Report of the Head of Development Management and Building Control

Address: 14 WILLOW TREE LANE HAYES

Development: Change of use from a 6-person House in Multiple Occupation (Class C4) to a 7-person House in Multiple Occupation (Sui Generis) (Application for a Certificate of Lawful Development for a Proposed Use).

LBH Ref Nos: 5516/APP/2025/3218

HD00257 - PL03

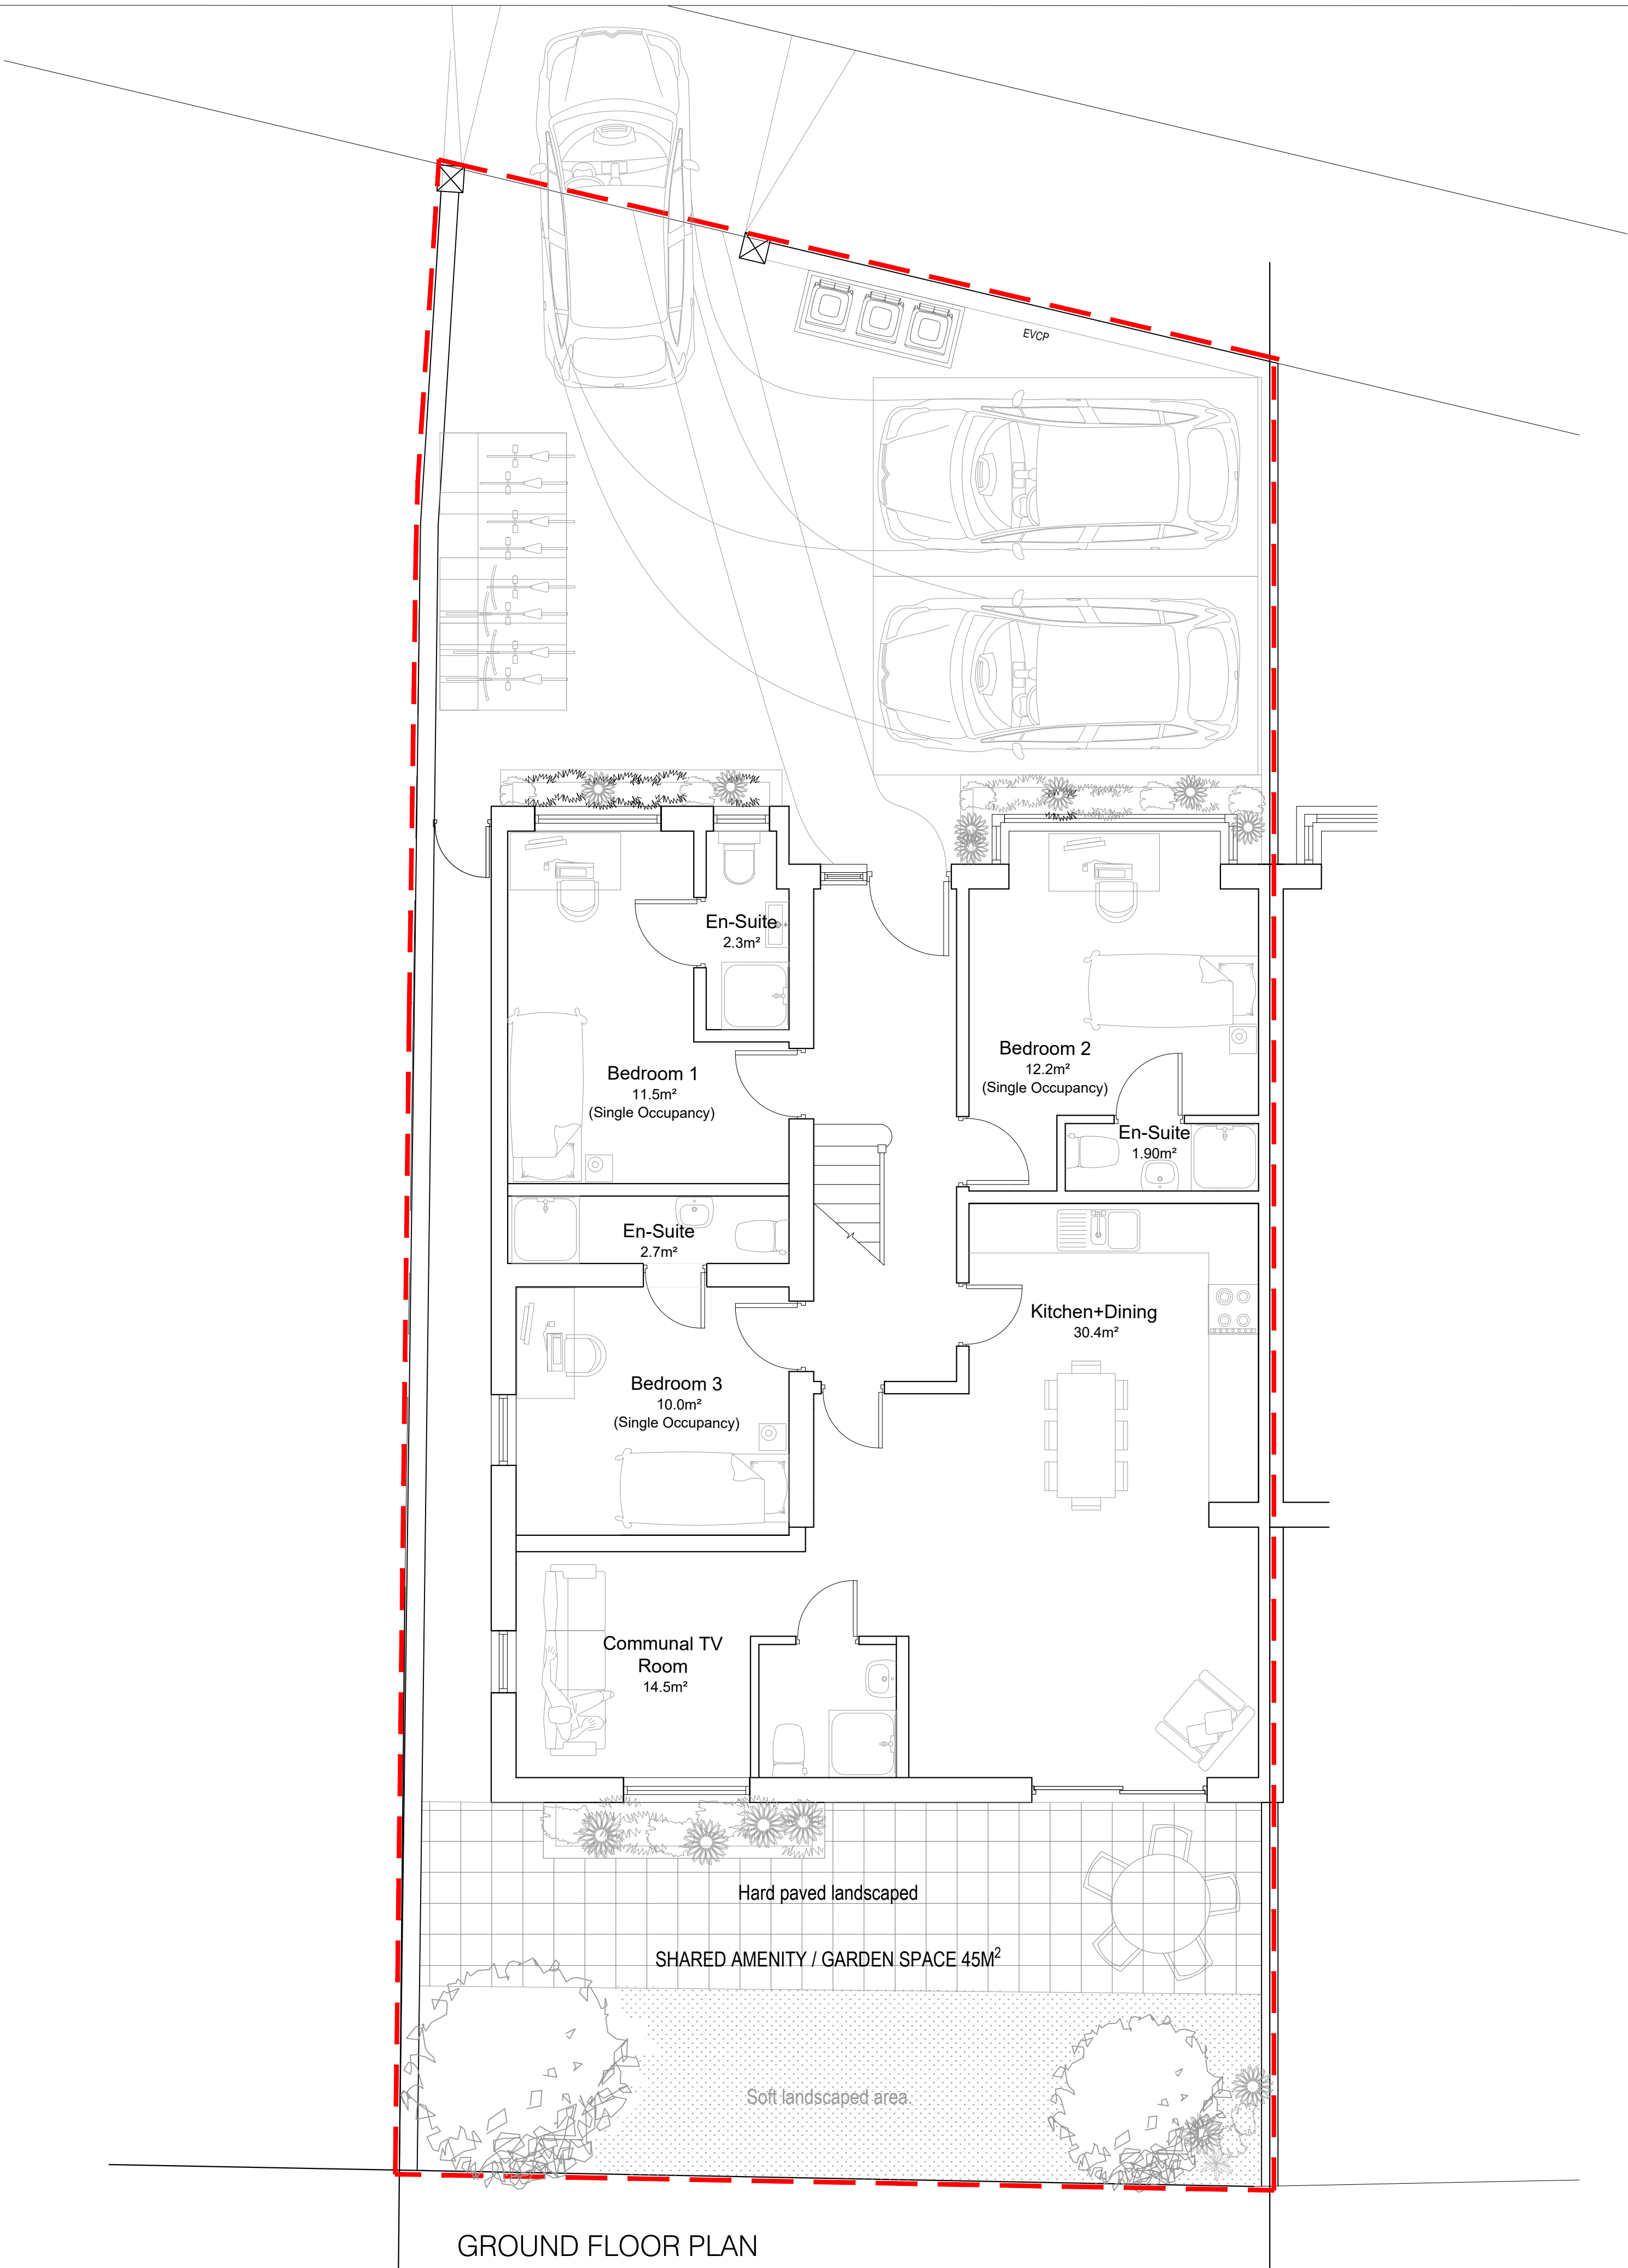
The submitted plans indicate the proposed use of the storage room and utility room as a 7th single occupancy bedroom with en-suite bathroom. The proposed bedroom measures 11.5m² with an en-suite bathroom (3.4m²).

Officers note the discrepancy with the submitted planning statement which states:

"The property has lawful use following the aforementioned certificate and is being used as a 6-person HMO (C4). This proposal is to use two of the bedrooms to provide double occupancy and therefore there is no physical internal or external development involved."

Officers confirm that the application is assessed on the submitted plans and description of development.
